RE: BP# 2017-00454_219 Anderson Street

Attached are the revised Code Compliance Plan and Floor Plan for Goodfire Brewing Company.

CODE COMPLIANCE PLAN

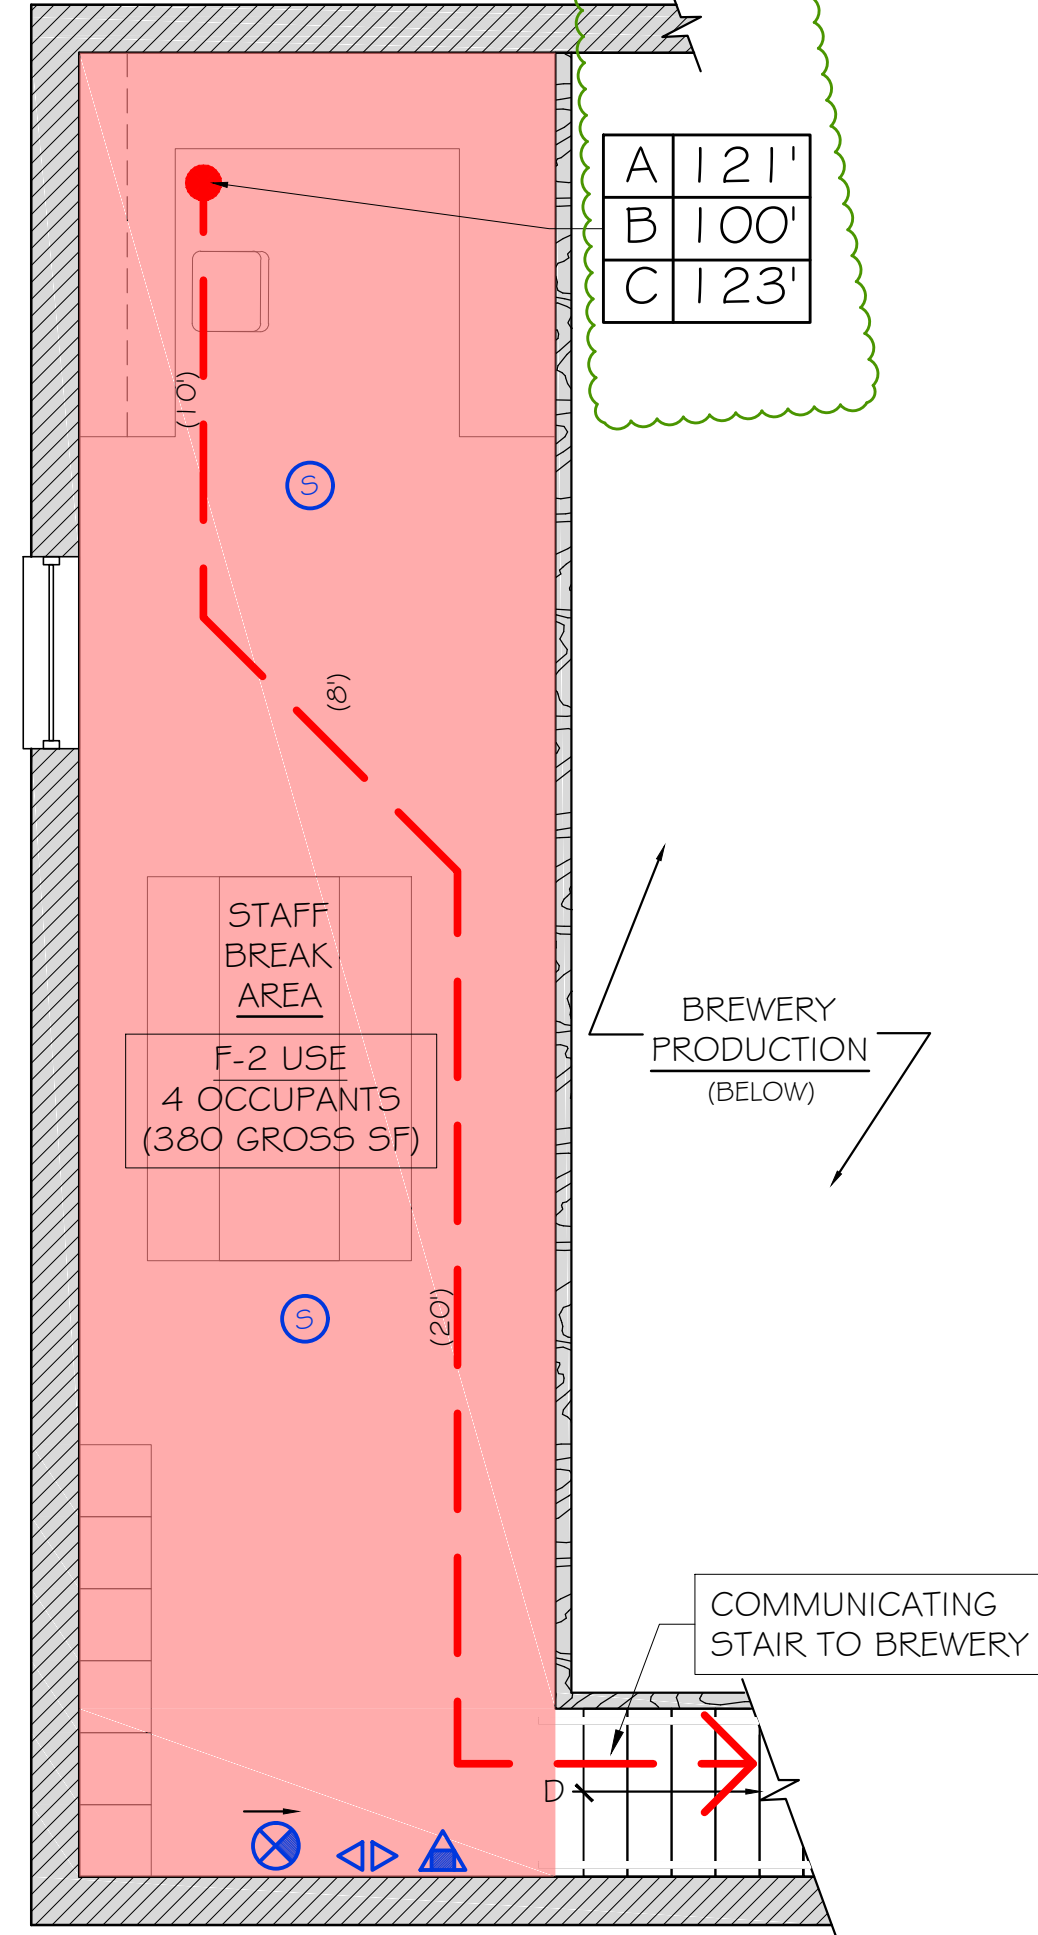
Unfortunately the NFPA 101 life safety code does not allow for you to take out equipment in a industrial occupancy (brewery). That factor is 100 sq ft gross per person. However the assembly area (tasting room) is based on 15 sq ft net per person in areas with tables and chairs. You also do not need to count the bathrooms in your occupancy load. The kitchen and Bar areas would be 100 sq ft gross per person, storage areas is 500 sq ft gross per person. All of these and more are in NFPA 101 Table 7.3.1.2 and are available for free online. As long as your total occupancy load is under 100 people by either using these formulas or reducing the size of the tasting than you will not need Fire Alarm system.

UPC 2015 per table 422.1 requires 2 water closets in an A-2 occupancy for 51-150 men and urinal per 1-200 men. It requires 3 water closets for 51-100 women all which would cover. In regard to the rest rooms, i will accept a total occupant use of less than 100 but not less than 50.

Per NFPA 1, the re-calculations you spoke of this morning Don't apply to industrial use, they do apply to assembly use though.

After much discussion in the office, I have decided that 78 occupants as shown in your drawing is not an accurate account of the possible or probably occupant load. I can agree to a number less than 100 for the occupant load based for your usable calculations.

A way needs to be devised to provide at least 2 and 1+1.

I recalculated the **gross areas** per occupancy uses, leaving out the Toilet Rooms, as you directed. The revised Occupant Load Table indicates these revisions per Code edition. I am still under 100 occupants, which means we do not need a fire alarm system, but have decided to add the Fire Alarm system in case you do not agree with my calculations. The additional symbols for the fire alarm system are shown in the NFPA Legend. We can not waste any more time going back and forth on this, as the Contractor is mobilizing on Monday, May 15th.

The Code Compliance Plan reflects the updated occupancy calculations based on our discussions, primarily regarding the significant area taken up by the brewing equipment/tanks. Depending on whether or not you both agree on the removal of the areas in violet from the calculated area, our occupant load is either 92 or 95.

PROPOSED FLOOR PLAN
 SCALE: 1/4" = 1'-0"

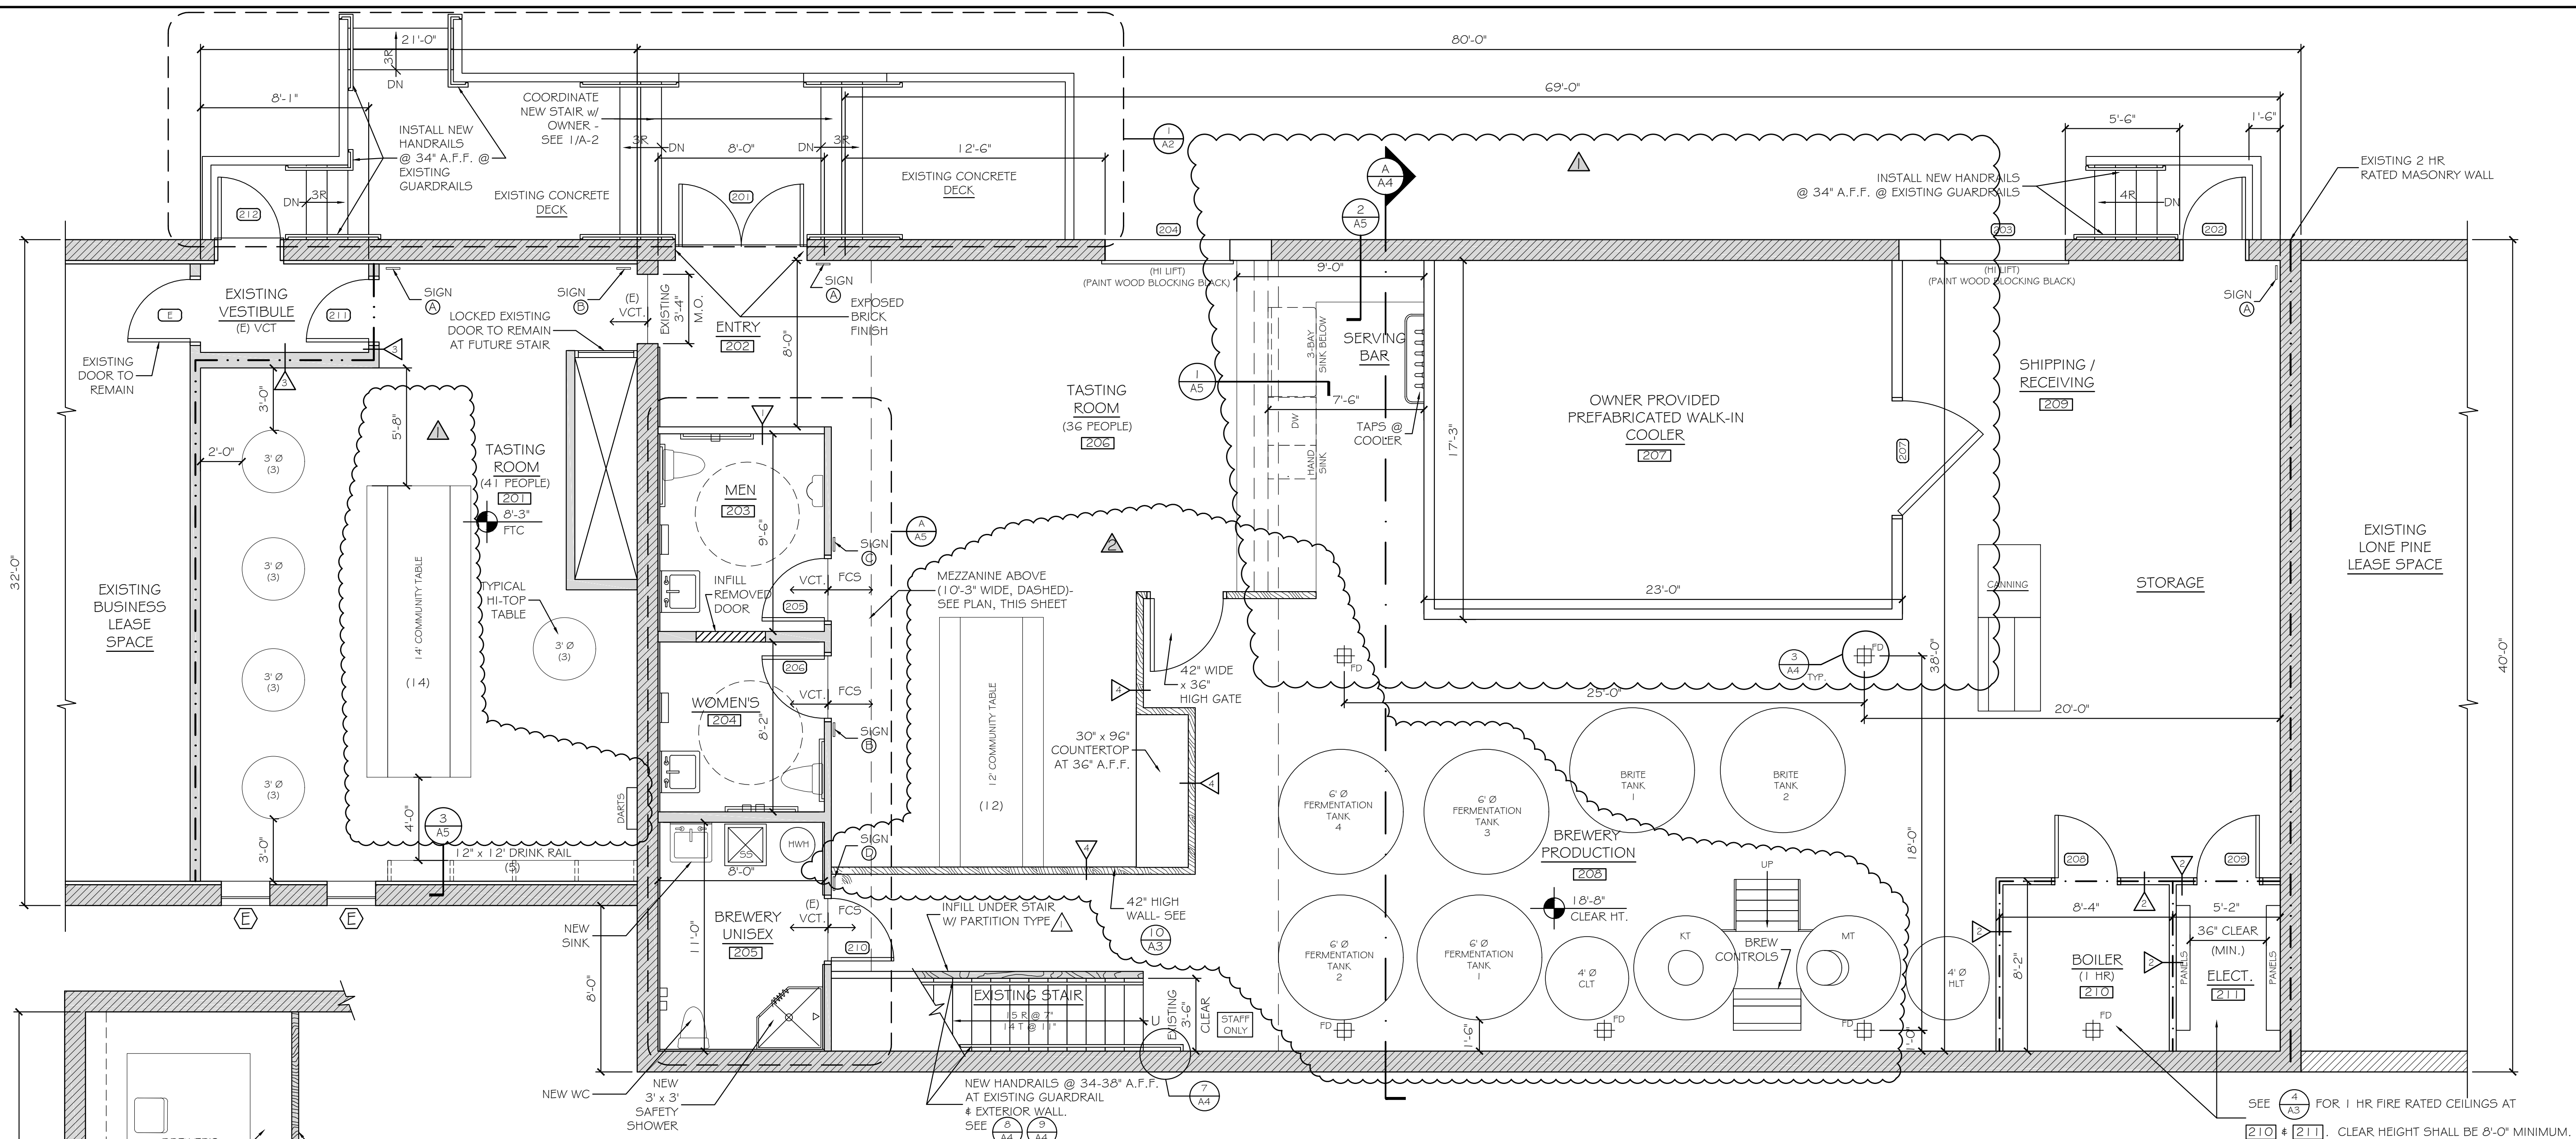
We will remove the door between the Kitchen and Women's Room.

Your watercloset count will be accepted however the door between the womens room and the kitchen must be removed (and filled) and the brewery must be posted to having no more than 80 occupants. Please also provide the ADA code analysis as to why there is no ADA access (shown) to the brewery.
